Question No. (Ref No.)	Question	Response
1.1.8	In Table 7.1 of the ES [APP-049] Redcar and Cleveland Borough Council (RCBC) identified that Dormanstown air monitoring station had seen some 1 hour NOx 'spike' concentrations. Why do you consider that this might have occurred and what effect would it have on nitrogen dioxide (NO2)? RCBC indicated a spike of up to 200ug/m3 whilst the applicant indicated 93.7. Why is there such a difference?	Please note that the spikes are hourly mean results of NOx shown as NO2. RCBC has a duty to report to DEFRA on NO2 both for hourly and Annual means. Seasonal variations – Ricardo Energy & Environment provide a data analysis service for RCBC and have provided the following explanation Pollution episodes are short periods of very high levels of pollution. On these occasions it is likely that hourly average NO2 concentrations higher than 200 μg m-3 will occur. There are two types of episode: In winter, when the ground is cold and there is little wind, emissions are trapped near to the ground. Winter episodes took place in 1991 in London and in 2001 in several locations (including Belfast, Glasgow and Manchester), with hourly average NO2 concentrations

Figure 11.4 Local Landscape Character Areas

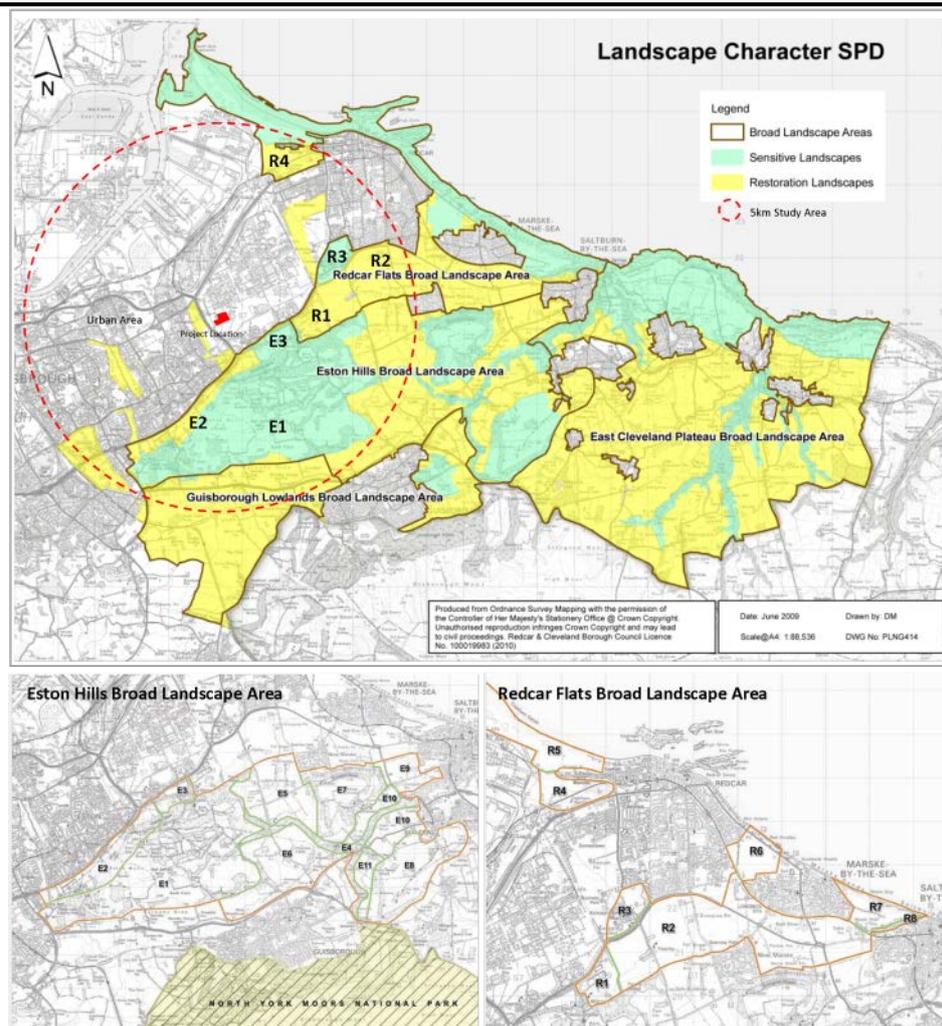
1.8.6	Figure 11.4 of the ES [APP-053] shows the Local Landscape Character Areas with the project location being within the urban area and not within any defined Local Landscape Character Area. Whilst not formally characterised, what is the local character of the area within which the Project is located? There does not appear to be a conclusion of the likely significant effects on the National Character Areas (NCA), although paragraph 11.34 of the ES [APP-053] states that NCA 25 would be largely unaffected due to topographical screening. On what basis was it decided not to assess the effects on NCA?	The application site is not situated within a landscape that is characterised under the Redcar and Cleveland LDF Landscape Character SPD (March 2010). Within the SPD there are landscapes that are characterised as Sensitive and Restoration, however this site is neither. It is considered that the site is situated within a landscape that is locally characterised as industrial in nature with some limited areas of open farm land to the west and the Eston hills further to the south.
